Our Ref: FP/251/19/PL

**Town & Country Planning Act 1990 (as amended)
Town and Country Planning (Development Management Procedure) (England) Order 2015
Application for Planning Permission**

Development Altering of existing west access to site to allow for vehicular access for emergency & maintenance purposes only. Drop kerb formed to allow for vehicular crossover, area to include a new area of secure bin storage for the school.
fence off waiting area separating it from public access & existing vehicular entrance areas.

Location Bishop Tufnell C Of E Junior And Infant School Pennyfields Felpham

project:	EXTERNAL WORKS		
location:	BISHOP TUFNELL PRIMARY SCHOOL, FELPHAM		
client:	SCHOOL GOVERNORS		
drawing:	SITE PLAN AND BLOCK PLAN		
scale:	1:500, 1:1250	page:	A1
drawn by:	JM	checked by:	AW
date:	NOV 19	drawing number:	2261.7/200
		revision:	A

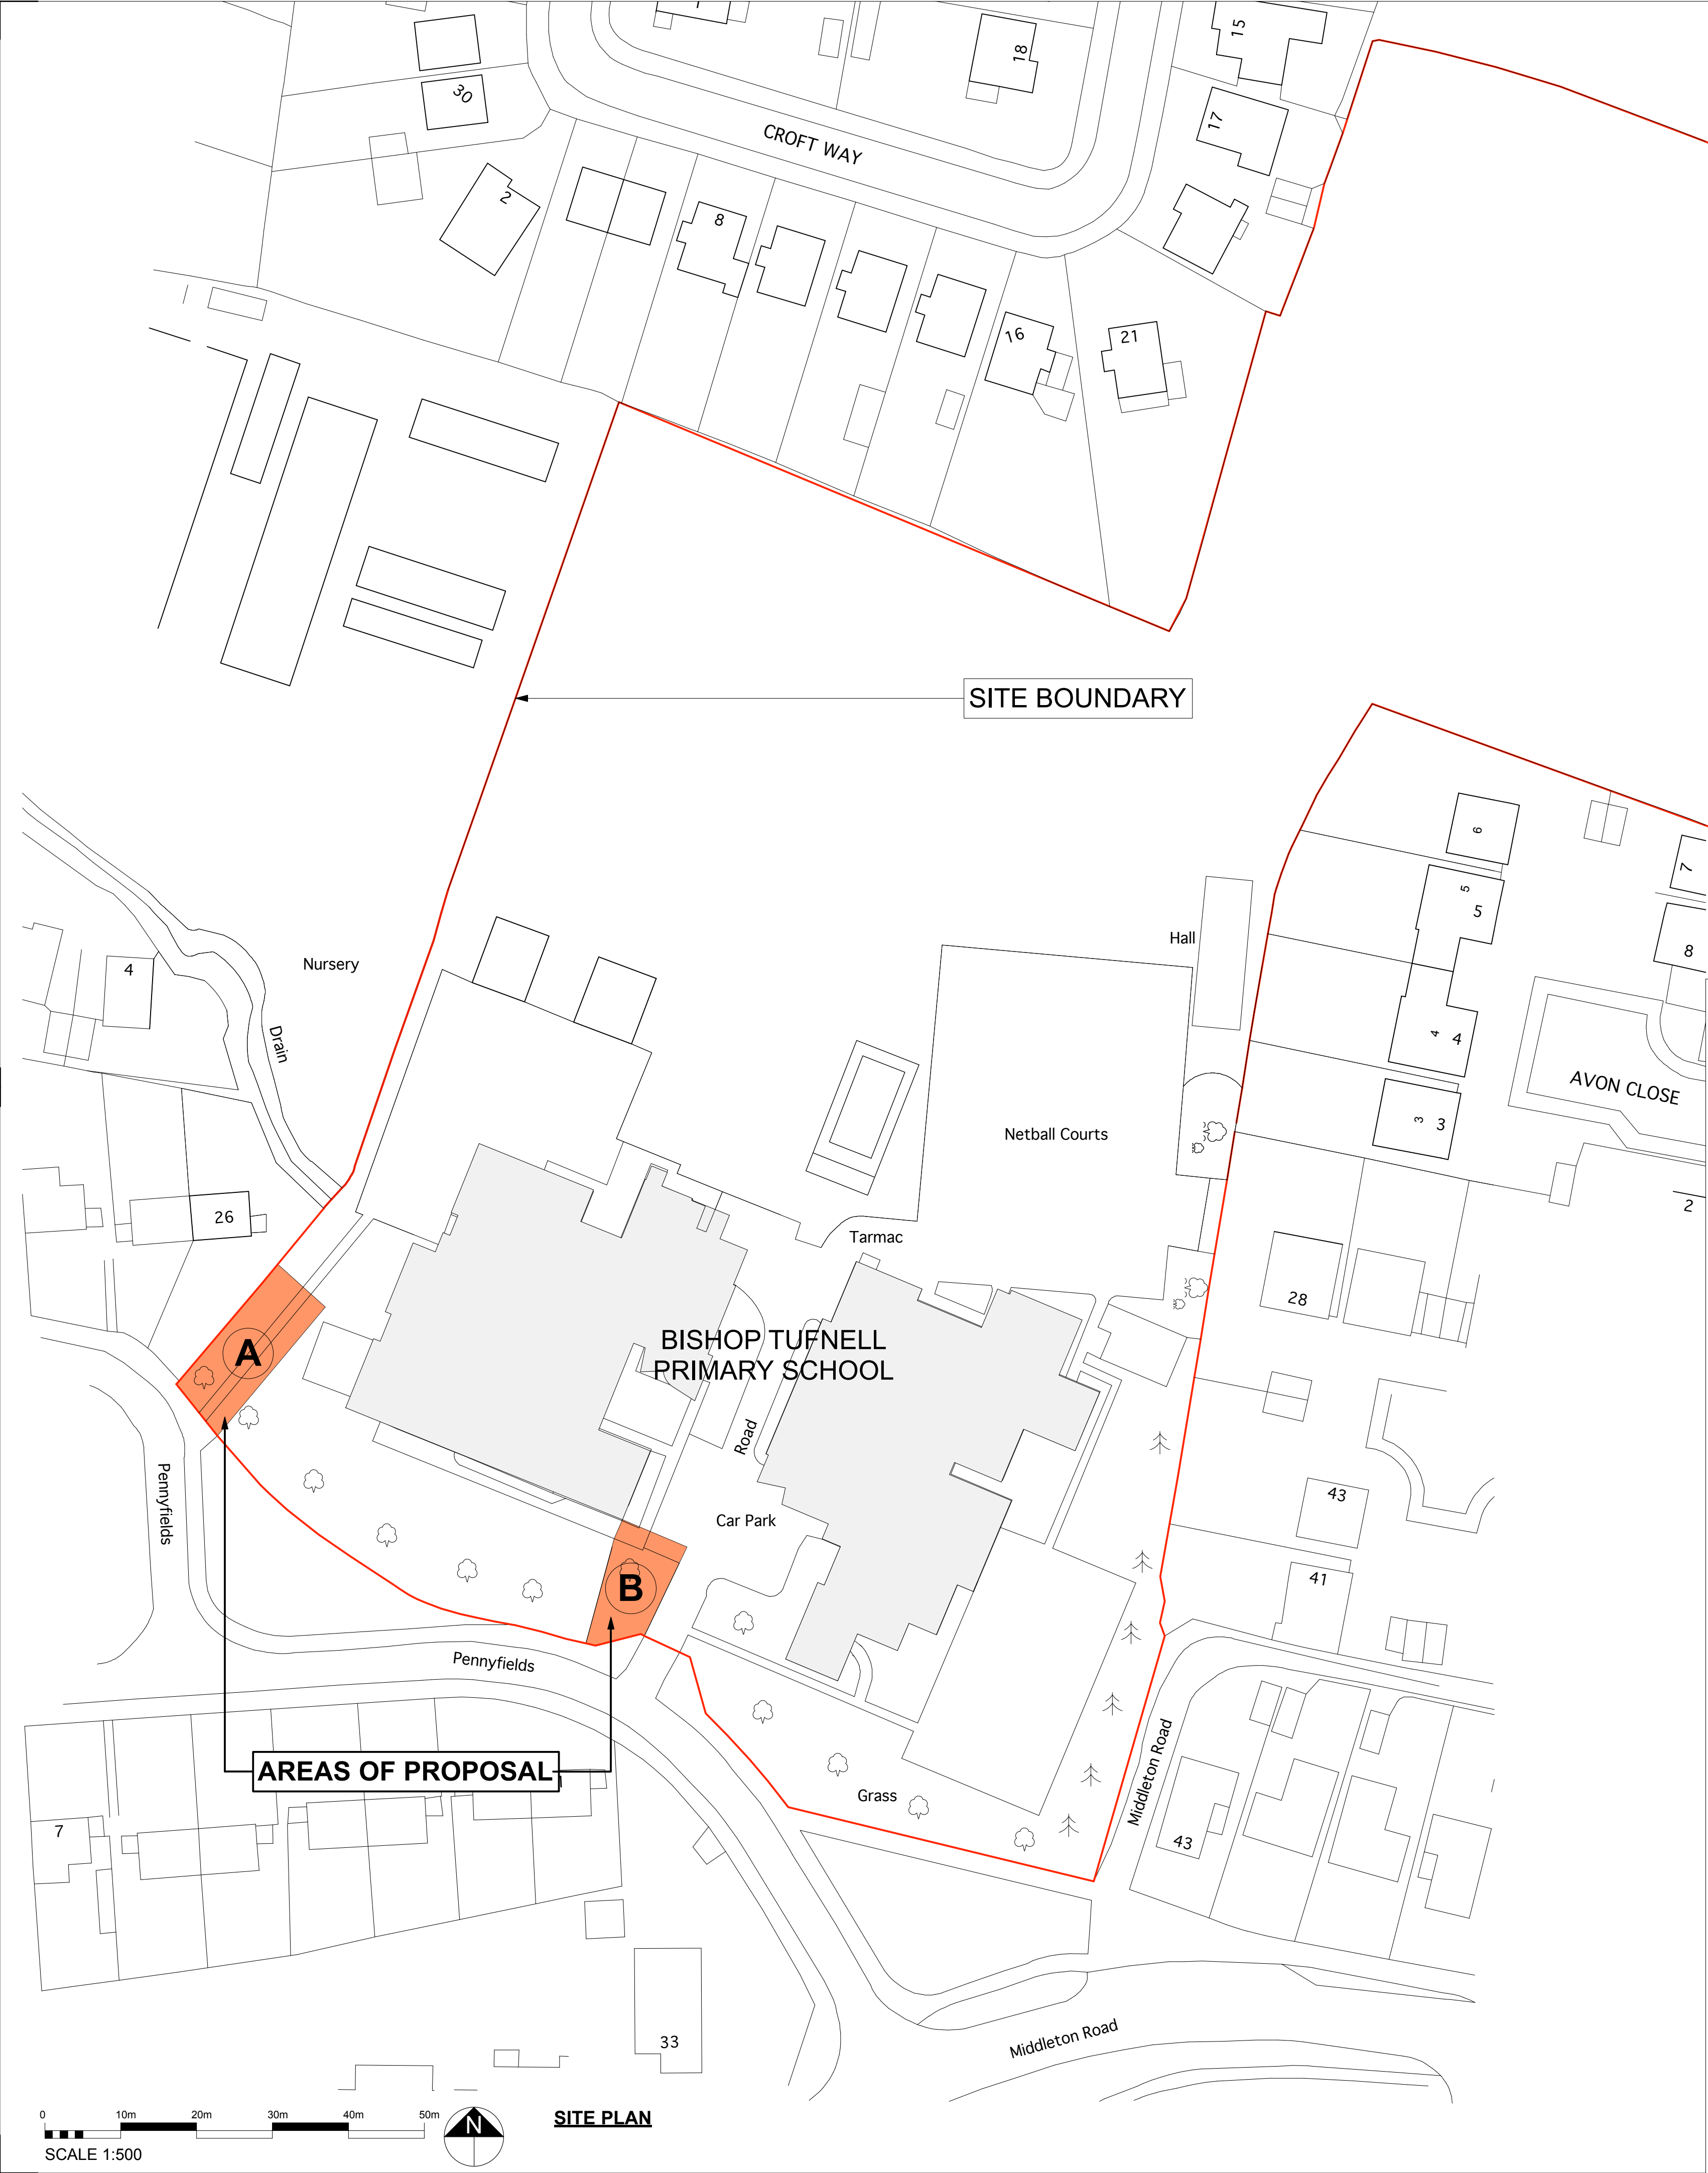
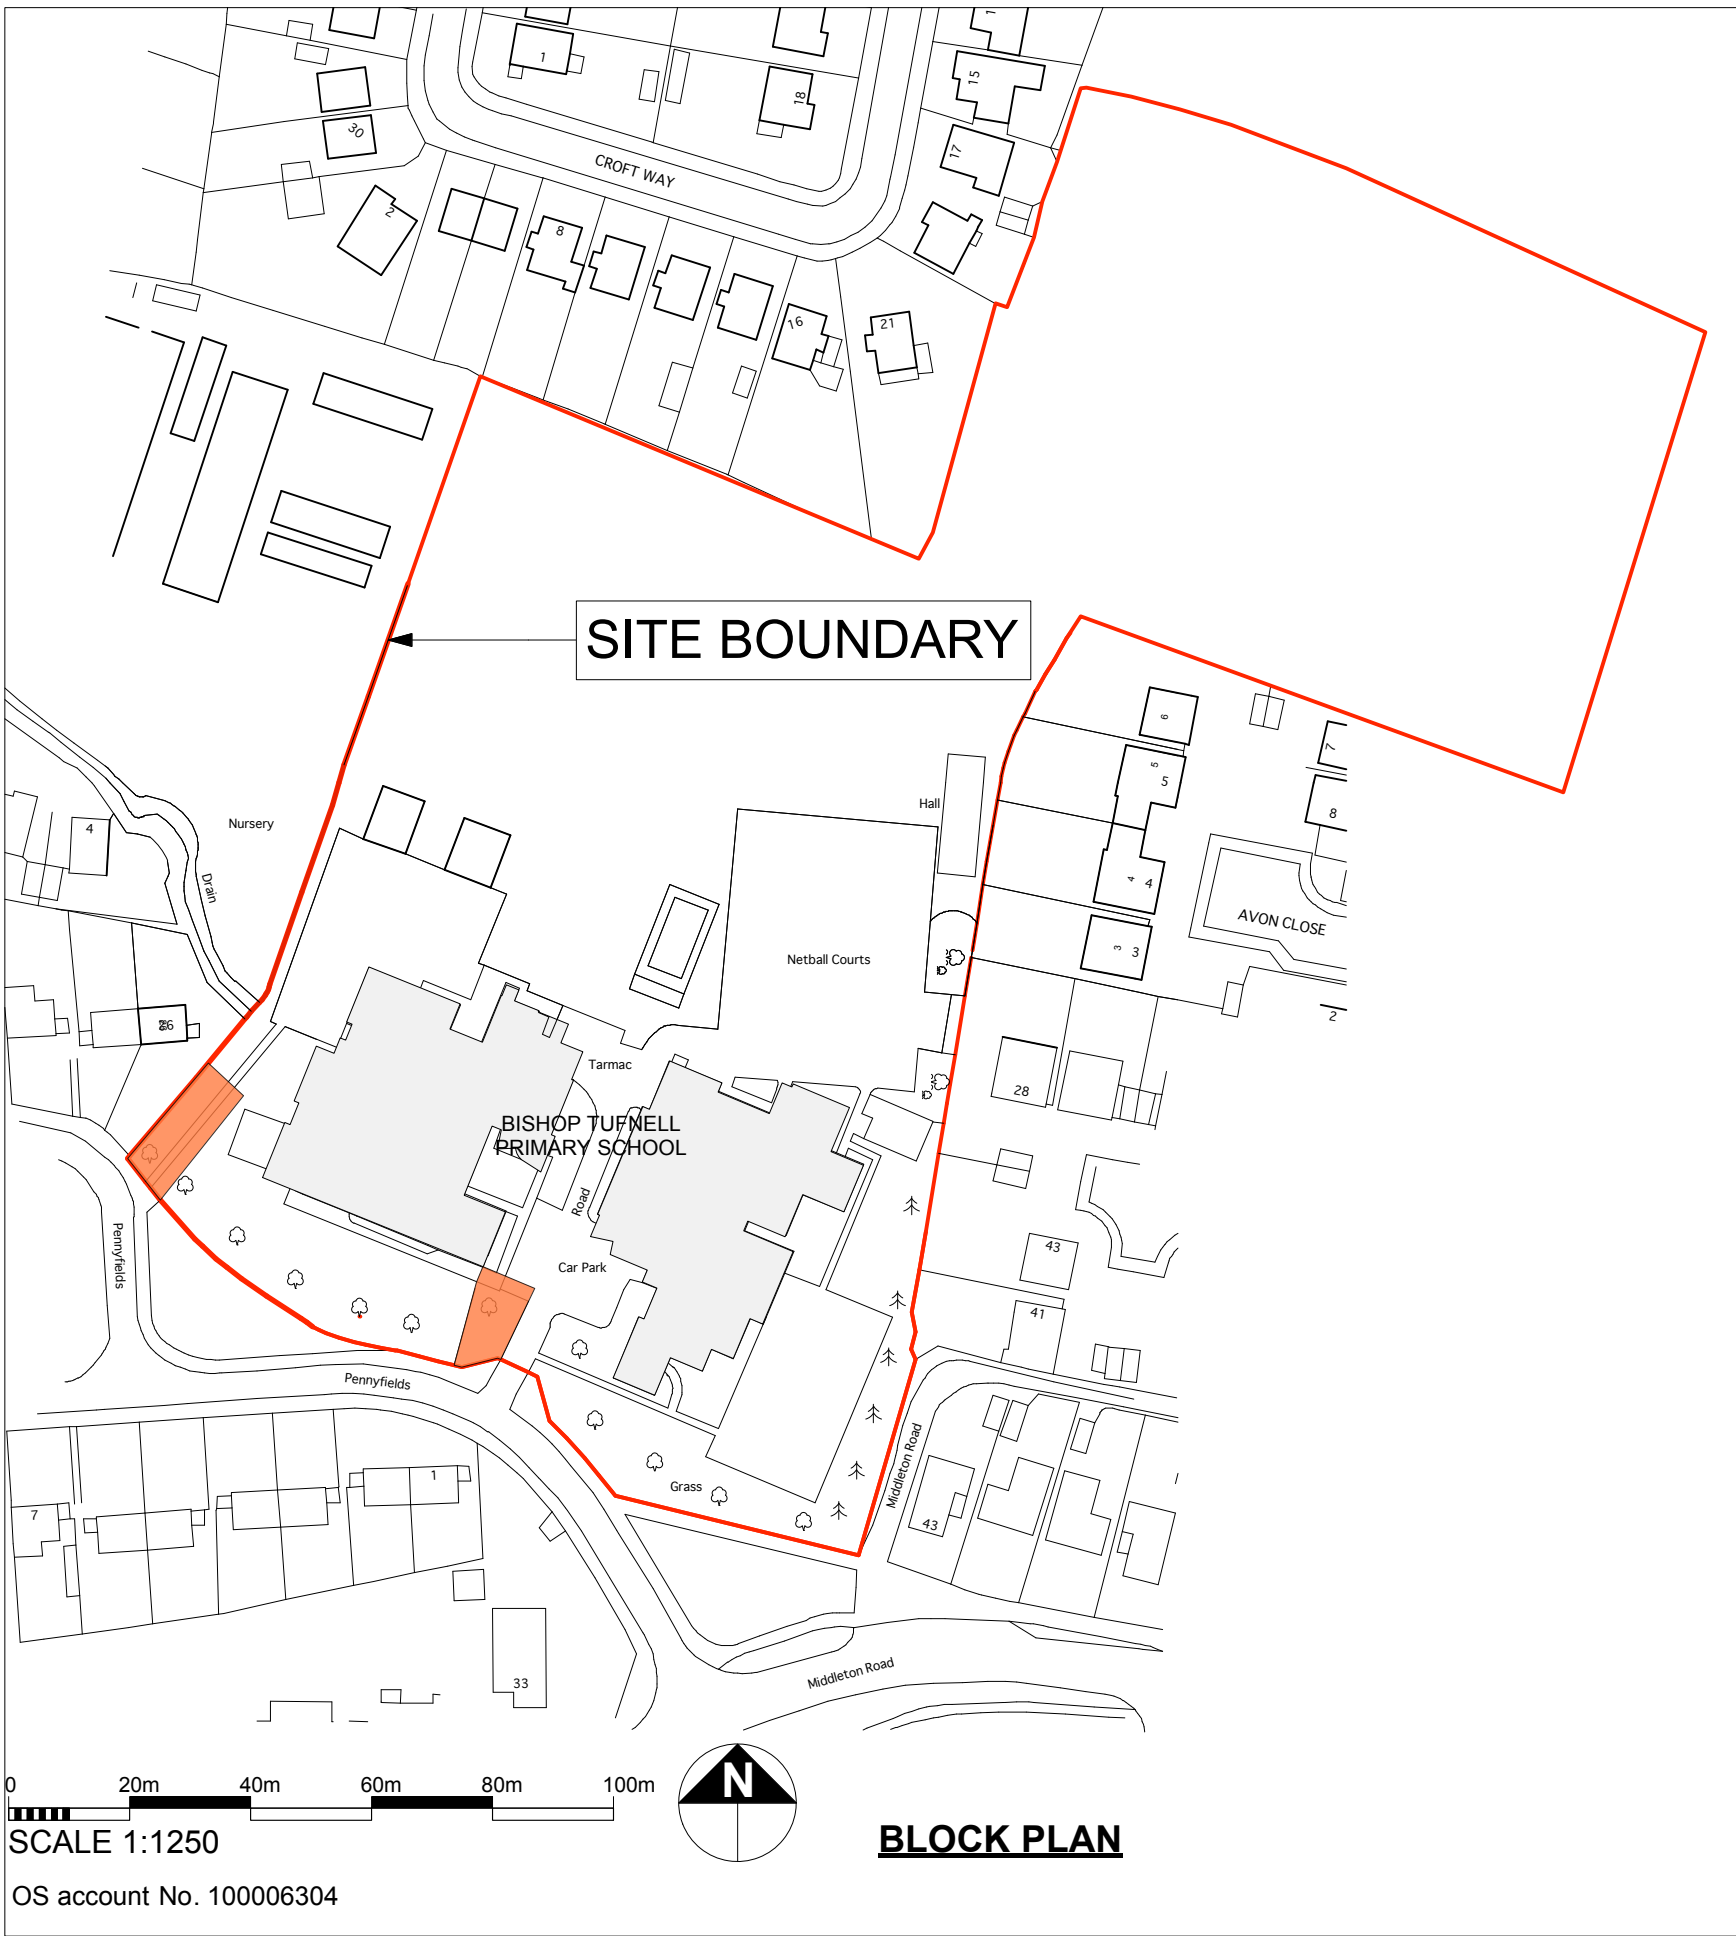
Location Plan Amend

Please provide a complete red edge.
